State of Washington
DEPARTMENT OF FISH AND WILDLIFE

March 17, 2021

SUBJECT: WDFW COMMENTS ON SWIFTWATER STORAGE CU-20-00006

WLC PROPERTY HOLDINGS LLC
SITE PLAN

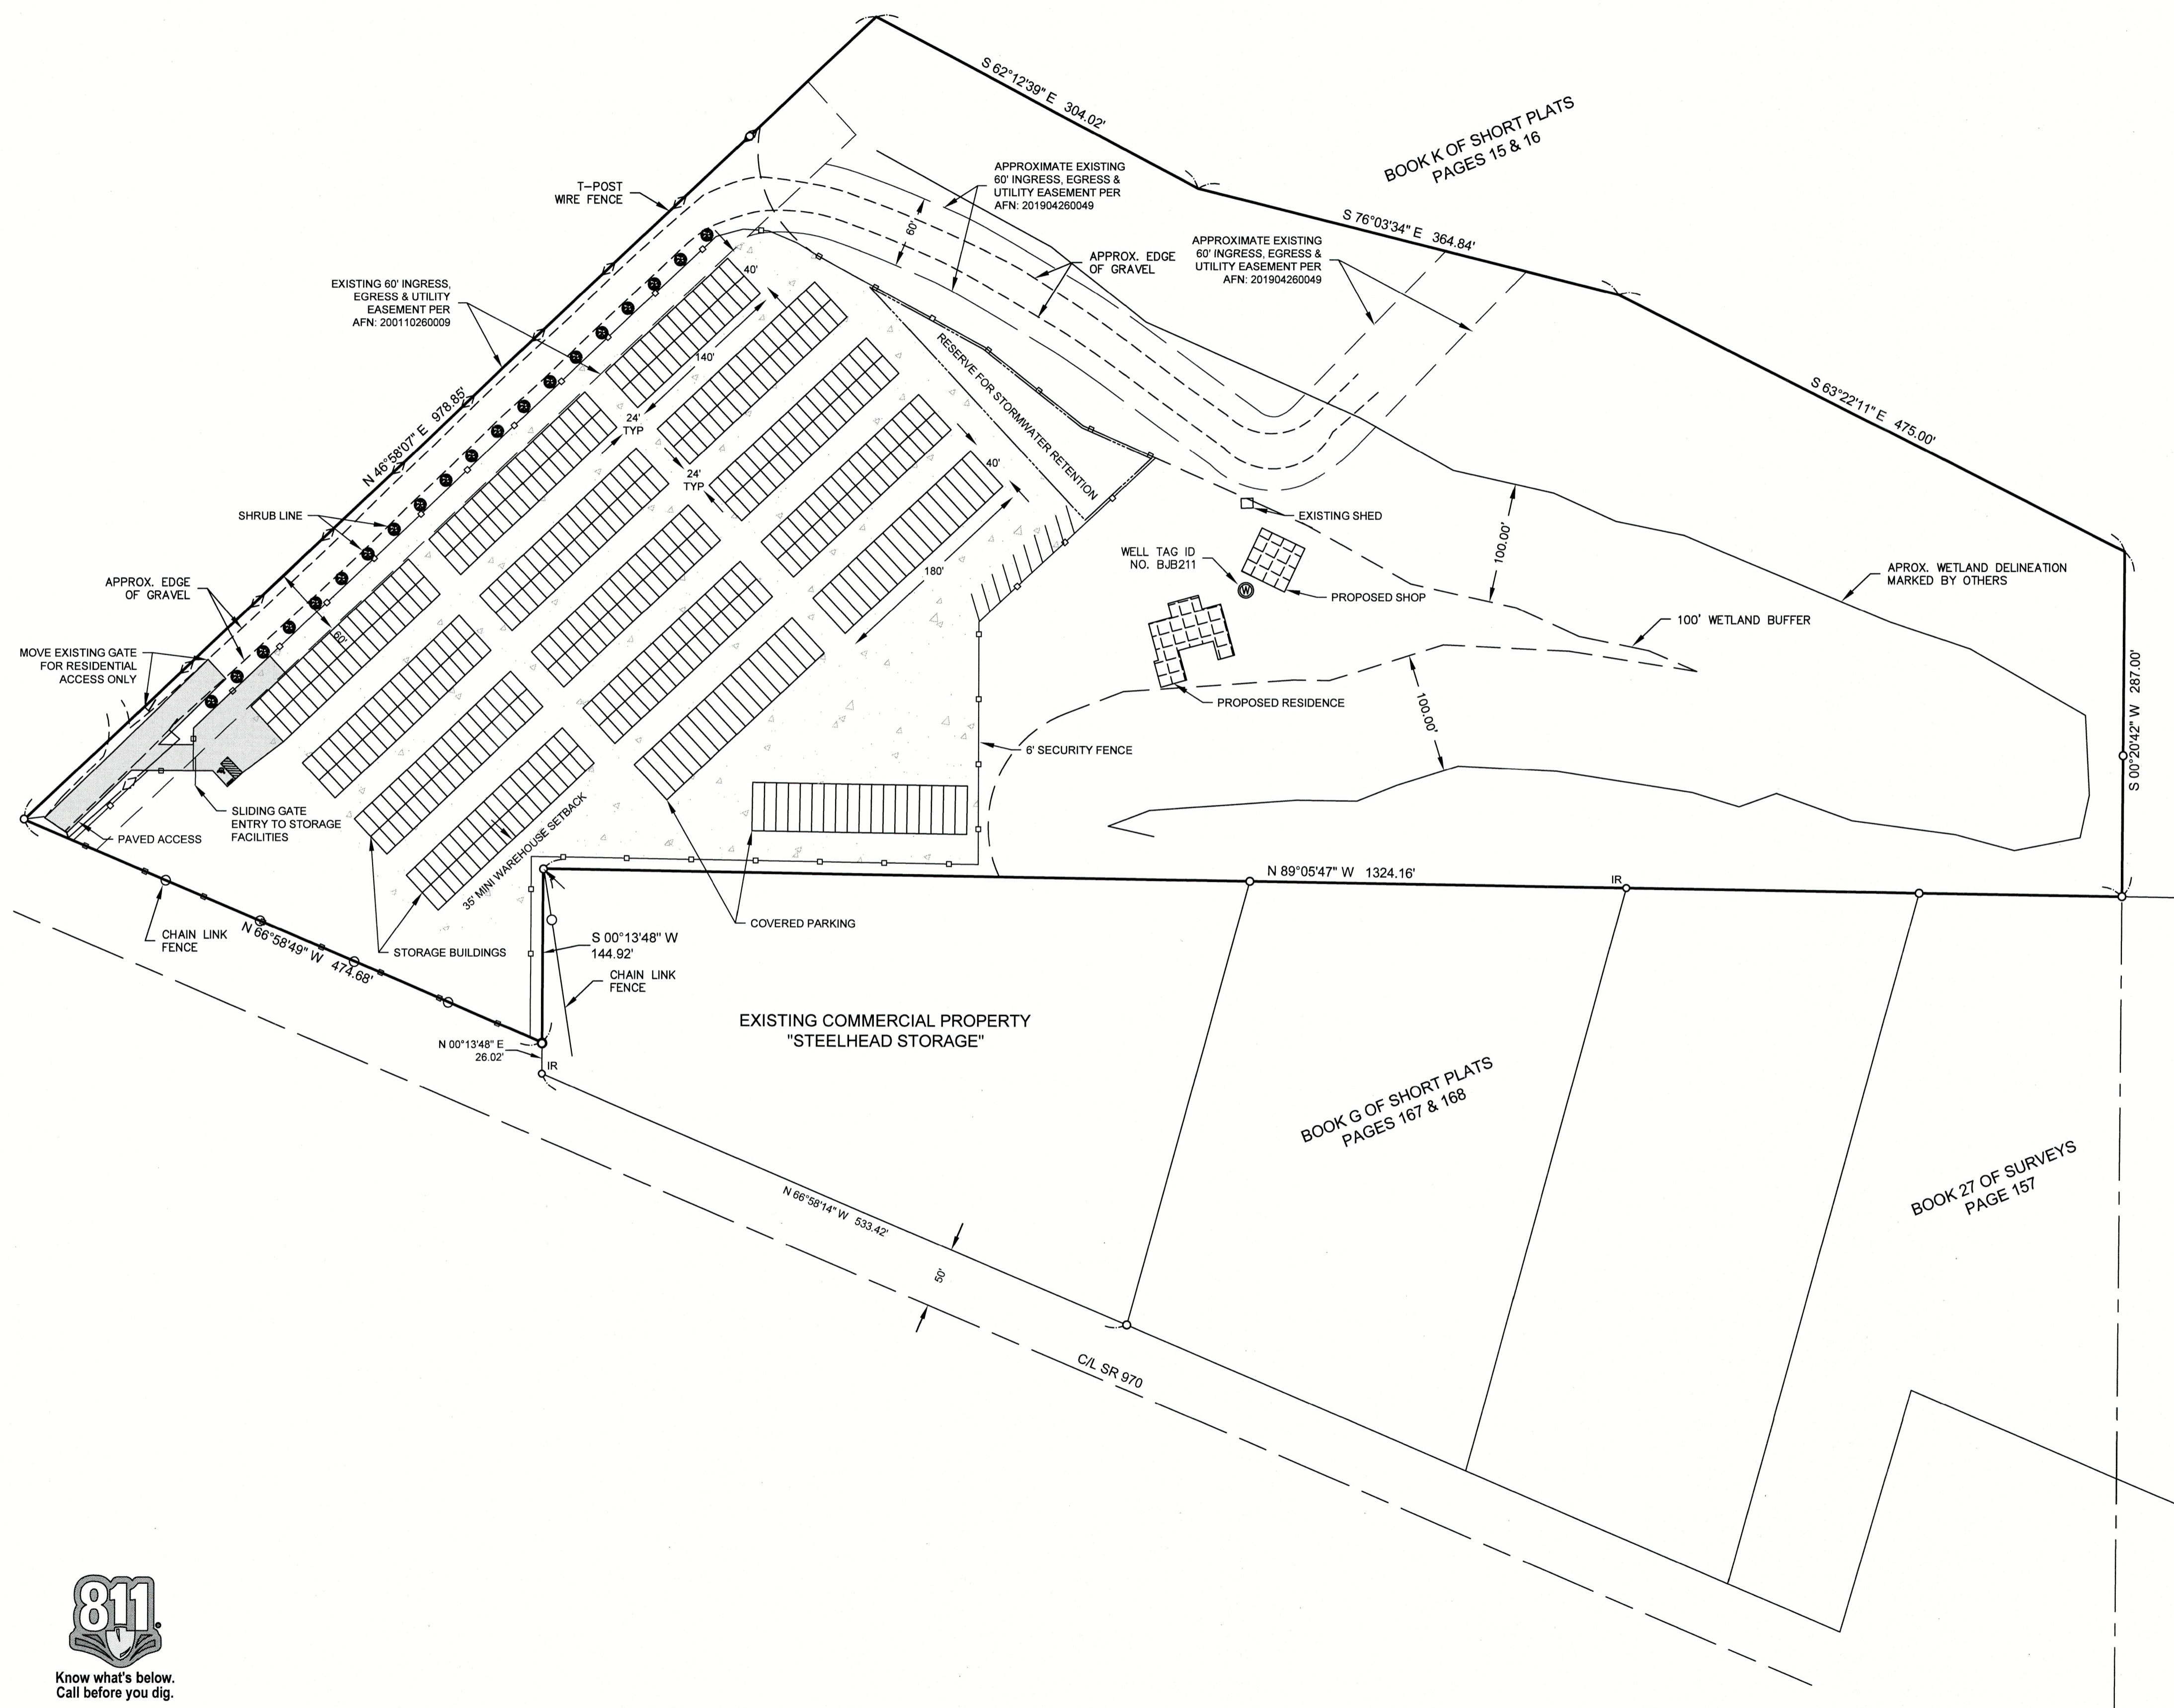
While the application materials address the Fish and Wildlife Habitat Conservation Areas and Wetlands on the property, they do not adequately address Frequently Flooded Areas. Nearly the entire parcel is mapped within the 100-year floodplain and yet the materials provide little information for how the site will be graded or potential compensatory floodplain mitigation measures. The flows within the wall-based channel on this property fluctuate seasonally with flows in the Yakima River. This is common with wall-based floodplain channels like the stream on this property. The water table on this property likely fluctuates in a similar manner. The depth to groundwater during all seasons will be critical to understanding the effectiveness of compensatory floodplain mitigation measures as well as stormwater treatment. The stormwater treatment area shown is adjacent to the wetland/stream buffer and we have concerns that there will not be adequate separation of the stormwater from these critical areas.

- Final site grading should be available for review to understand how the changed topography may or may not impact the associated critical areas and their functions and values.

- Final stormwater management plans should clearly show that stormwater can be captured and treated without impacting groundwater or critical area buffers throughout the seasons and fluctuating water levels. Please consider using pervious surfaces, particularly in the open and covered parking areas to reduce stormwater runoff.
- Please provide additional details for the operation of the RV repair facilities and primitive campground areas so we can understand how these may or may not impact critical areas.
- Please direct lighting downward to comply with the [DarkSky](#) best practices
- When possible, please use native vegetation within the landscaping. It will provide additional wildlife benefits and in many cases is drought tolerant so will require less maintenance. WDFW will be pleased to work with the applicants to make specific recommendations based on their needs.
